Our Ref: AB/21/19/T

**Town & Country Planning Act 1990 (as amended)
Town & Country Planning (Tree Preservation) (England) Regulations 2012
Application for Works to Tree(s) on trees subject to a Tree Preservation Order (TPO)**

Development Remove all self-set trees and vegetation consisting of Buddleia, Bramble, Silver Birch, Ash and Goat Willow to ground level to facilitate construction of new properties.

Location 3 Ford Road Arundel

Site Plan

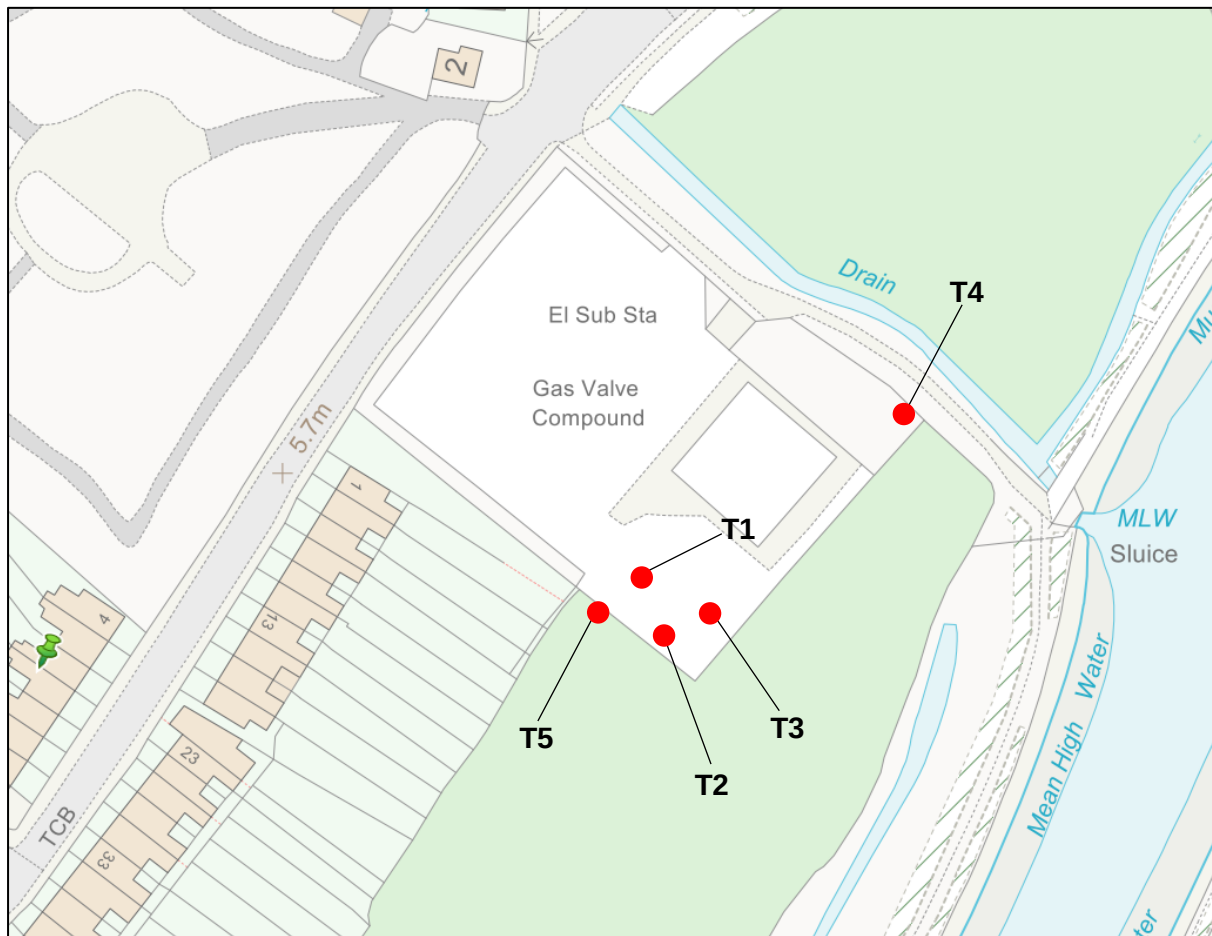
Please provide a location plan with 2 road names clearly marked.

Please mark the location of each tree and the species.

Please confirm number of trees to be felled.
